**DEVIATION REQUEST
AND DECISION FORM IN
ASSOCIATION WITH A
REQUEST FOR A PUD
MODIFICATION FROM
THE ECM**

A deviation from the standards of or in Section **EMC 2.2.4.B.7 (figure 2-17), Table 2-7** of the Engineering Criteria Manual (ECM) is requested.

Typical urban local (low volume) cross section

**PRIVATE ROAD (30' WIDE TRACT)**

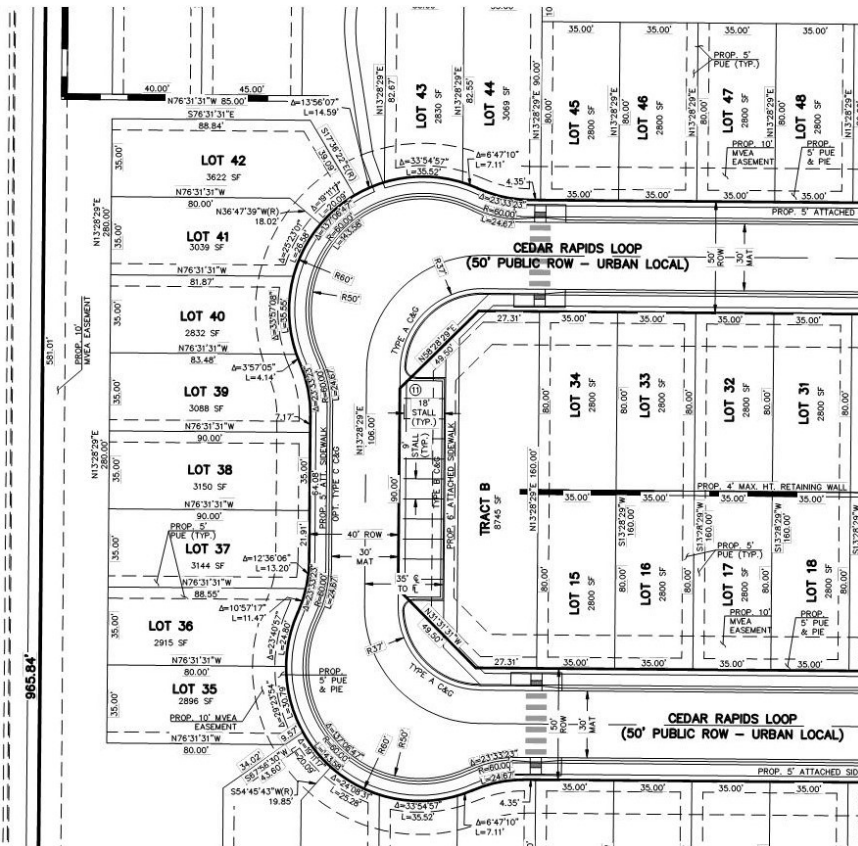
Please provide exhibit/plan showing the location of the private streets and a cross section of the proposed road.
